From: Kate Giddings <kate.giddings@arun.gov.uk>
Sent: 12 May 2022 16:11
To: Anita Gardner <Anita.Gardner@arun.gov.uk>
Cc: Planning.Responses <Planning.Responses@arun.gov.uk>
Subject: F/4/22/PL - The Glasshouse, Wicks Farm, Ford, BN18 0DF

In relation to the above application, please may EH comment as follows:

date	scale @ A0	drawn	checked
21.10.21	as shown	GBC	GBC
project no.	drawing no.	rev.	
2137	PA02	P03

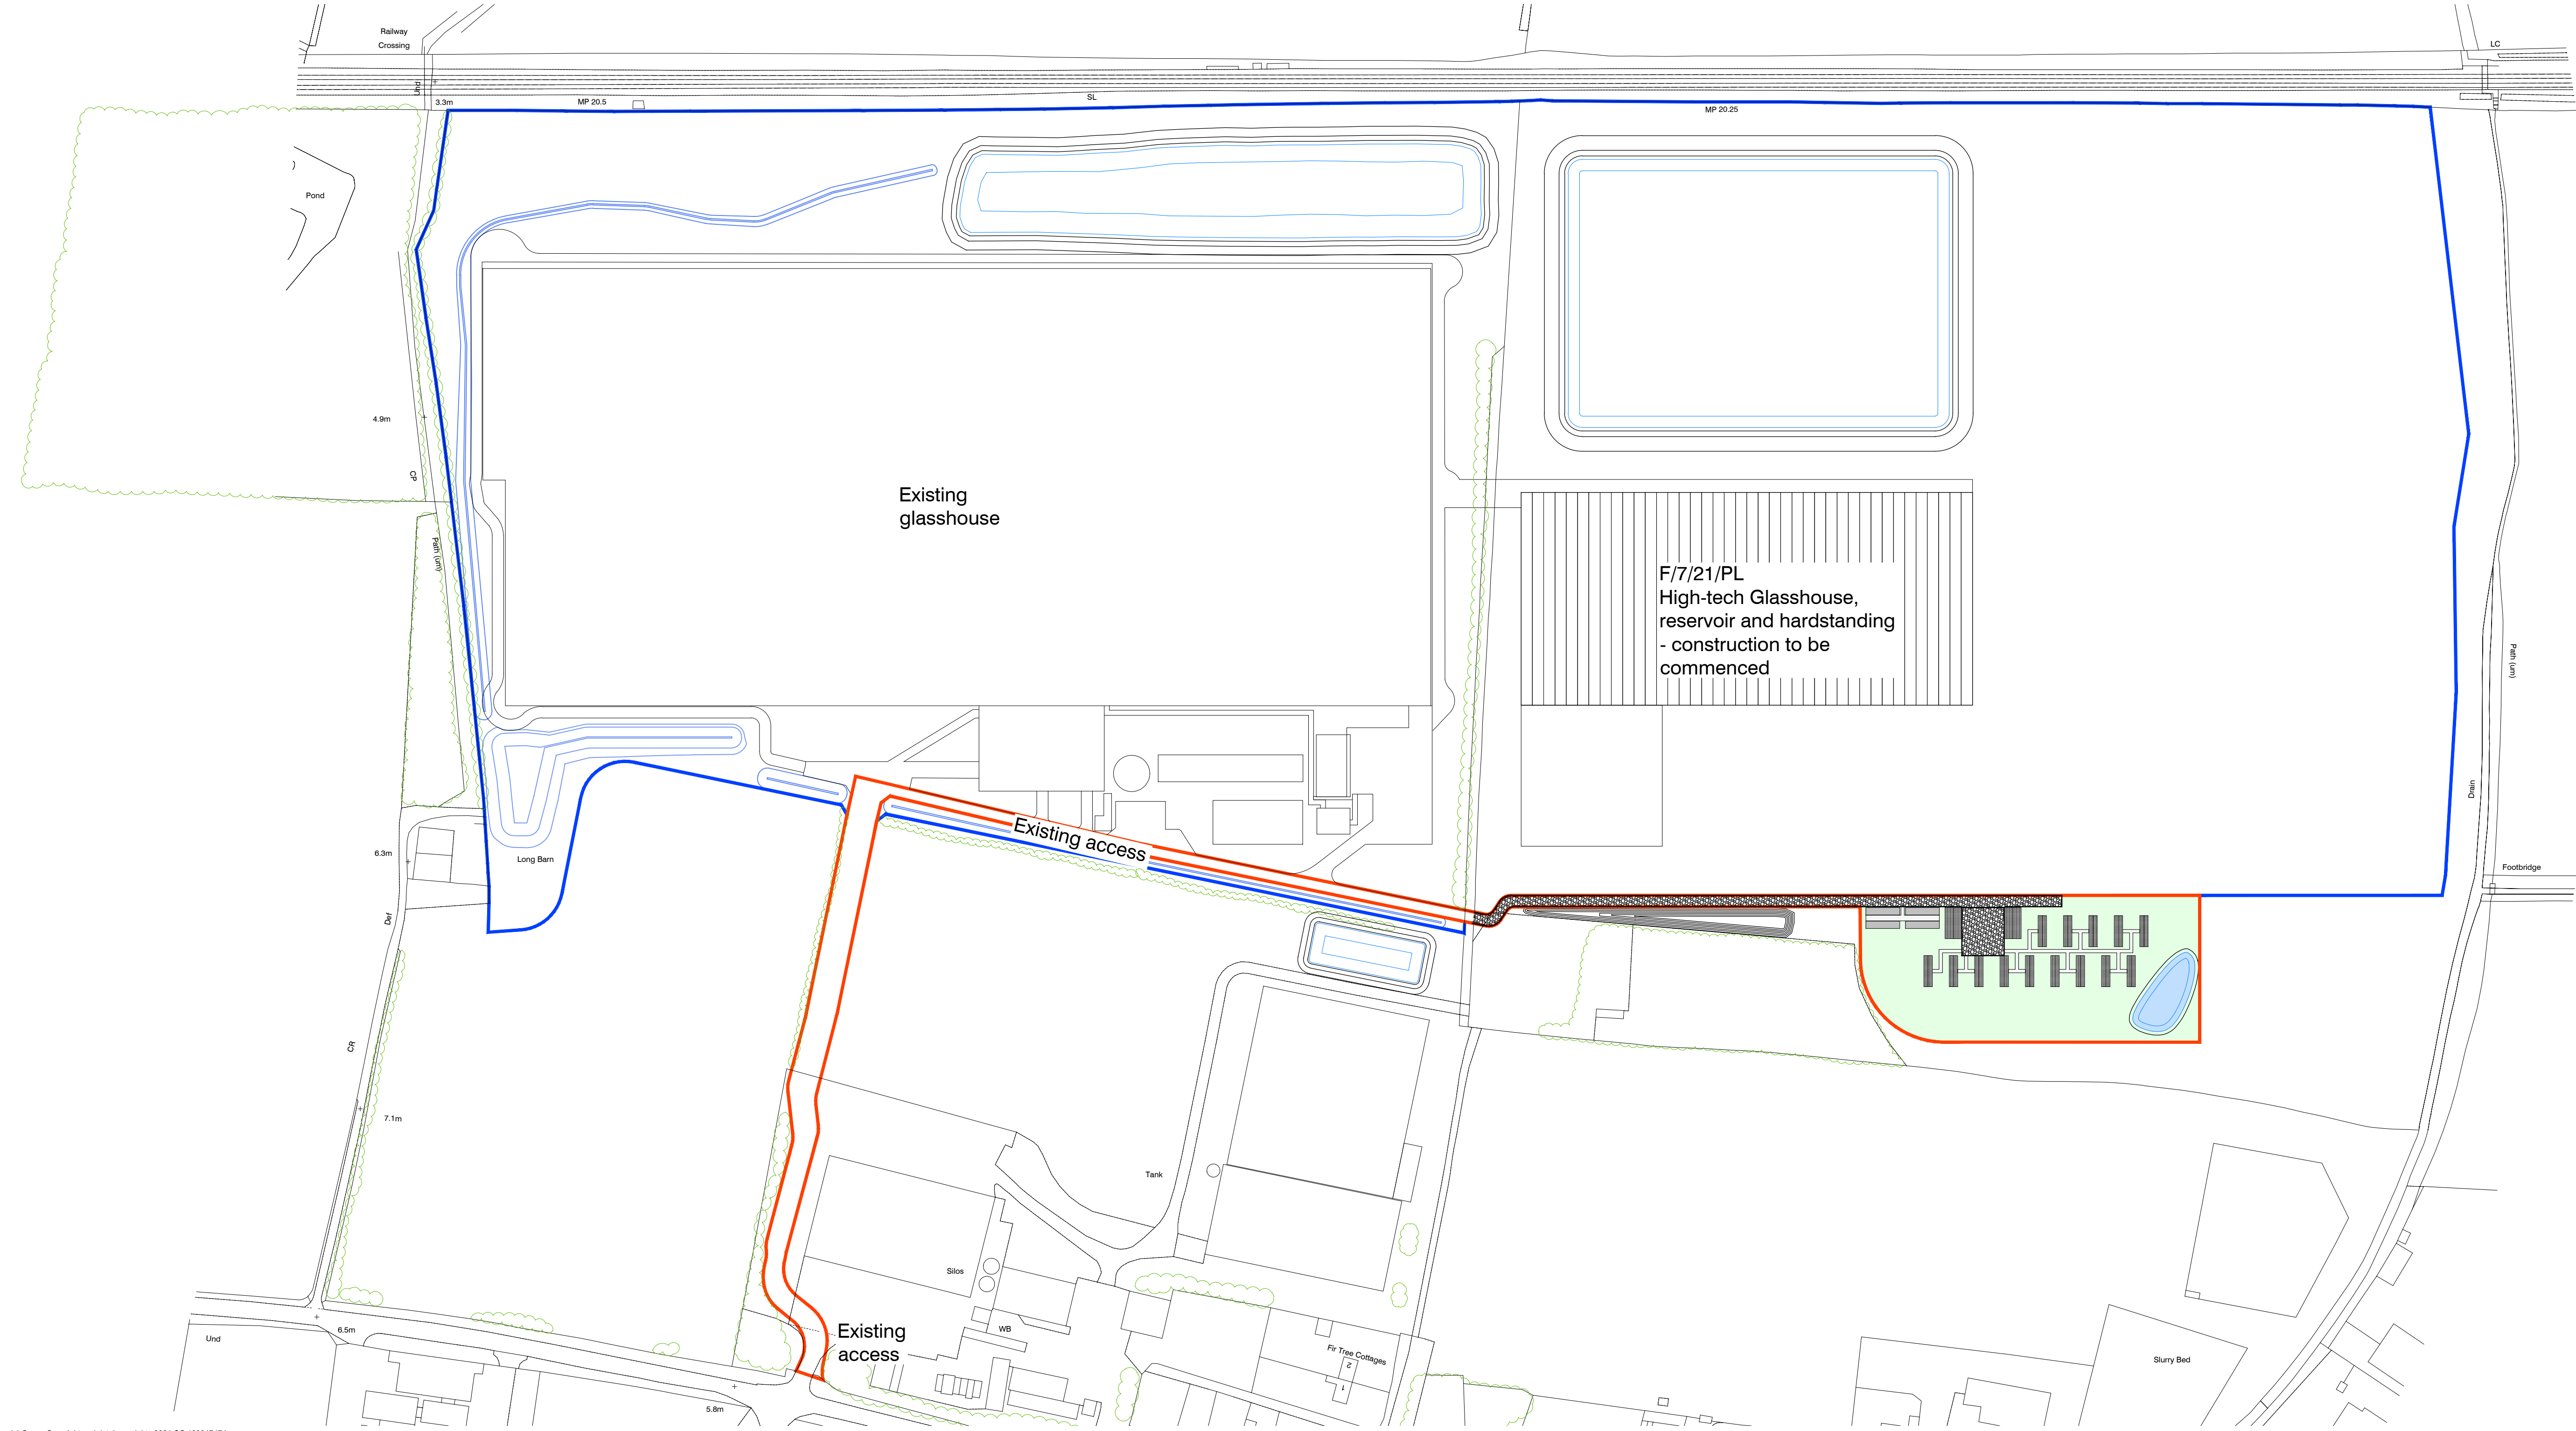
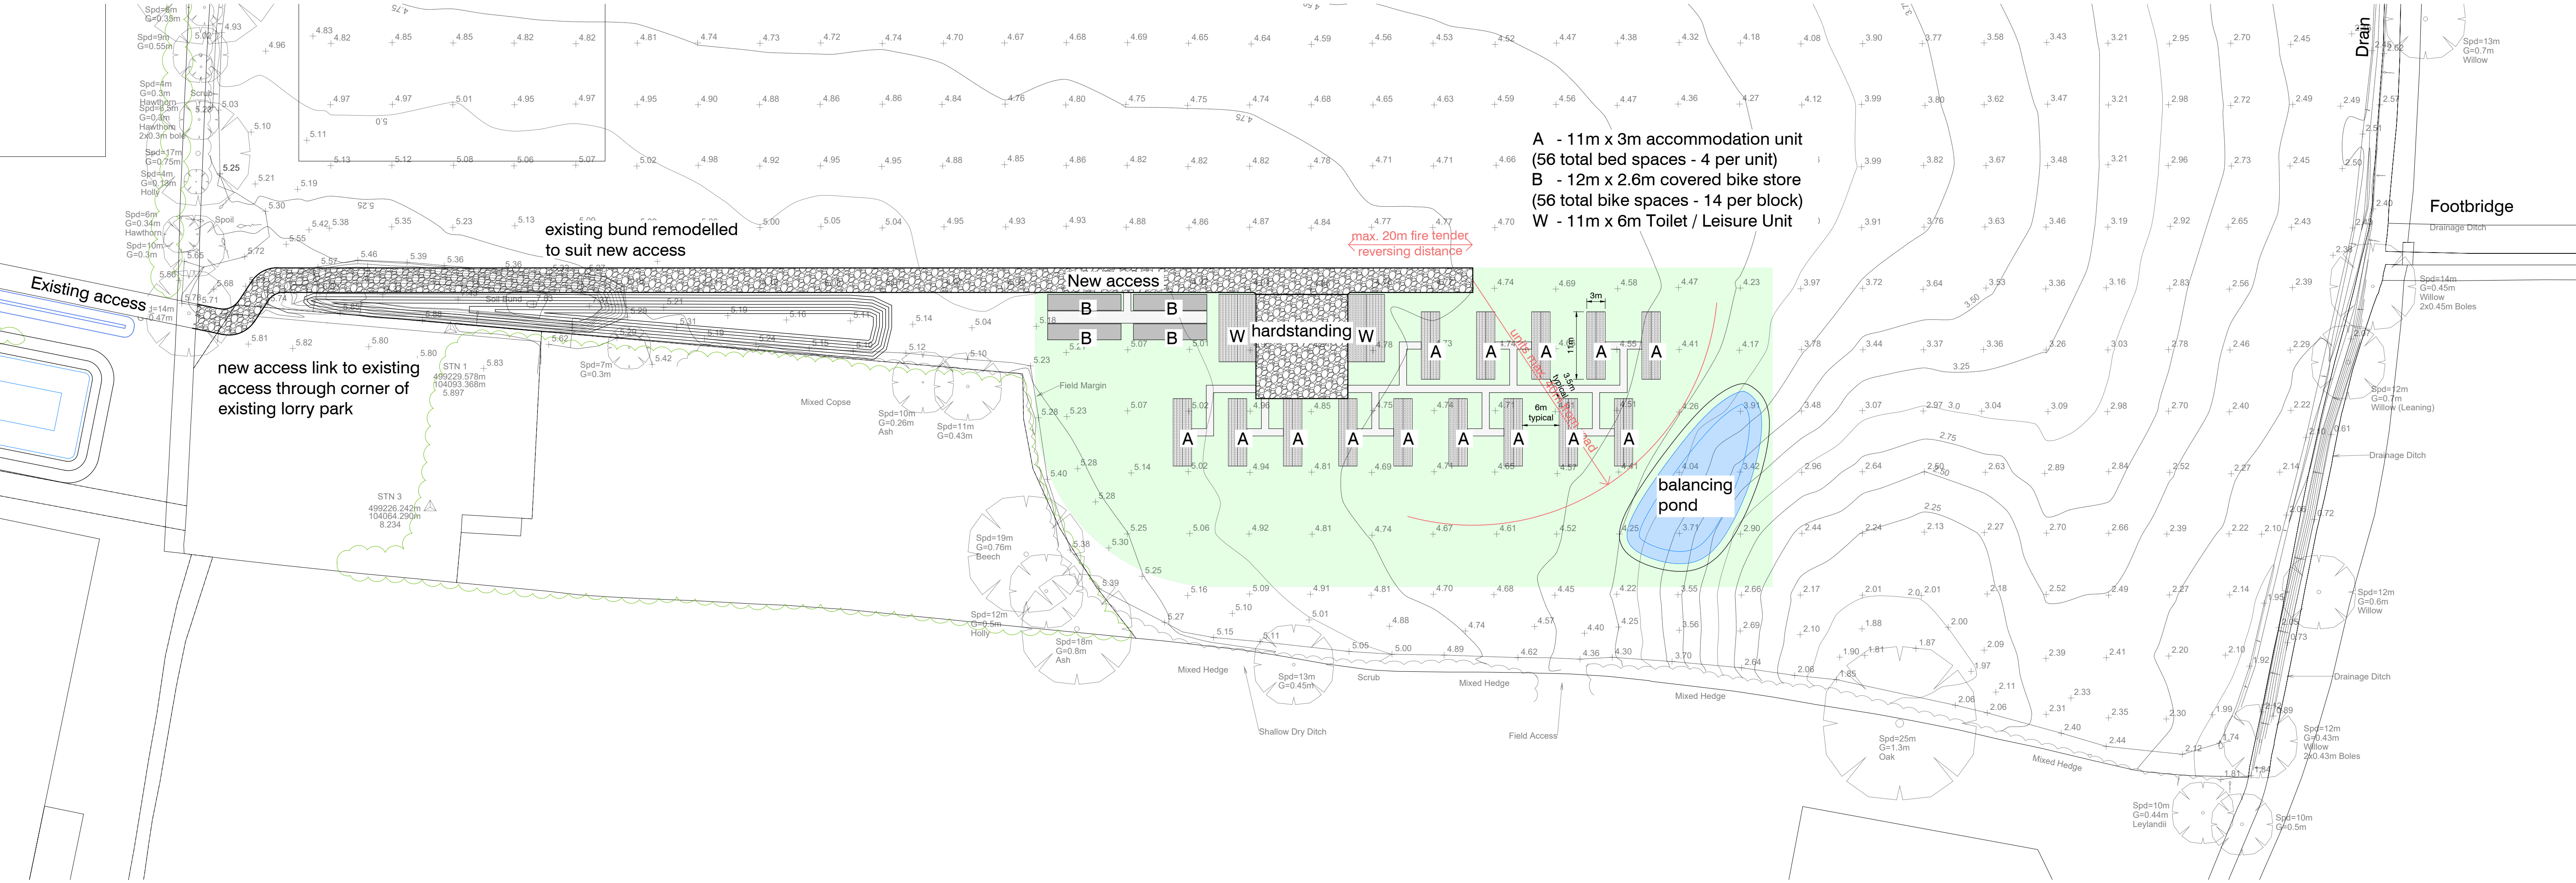
- Please may further detail on the proposed lighting scheme be provided.
- It is noted that the proposal includes an extension to the existing parking area; please may the applicant provide greater detail on the proposed parking provision (e.g. a plan showing the number and location of parking spaces) and confirm whether any allowance for electric vehicle charging will be made.

- Please may the applicant confirm whether the caravans will be stationed on bases and if so, how these bases will be constructed.
- Please may the applicant confirm how the access between the caravans and the hardstanding (as per the submitted block plan) will be constructed.

- The application states that the caravans will be connected to the mains sewer but no detail of water supply/electricity/gas etc. has been provided – please may the applicant confirm details.

- It should be noted that each caravan should be stationed a minimum of six metres from another caravan. No caravan or other combustible structure should be positioned within three metres of the site boundary.
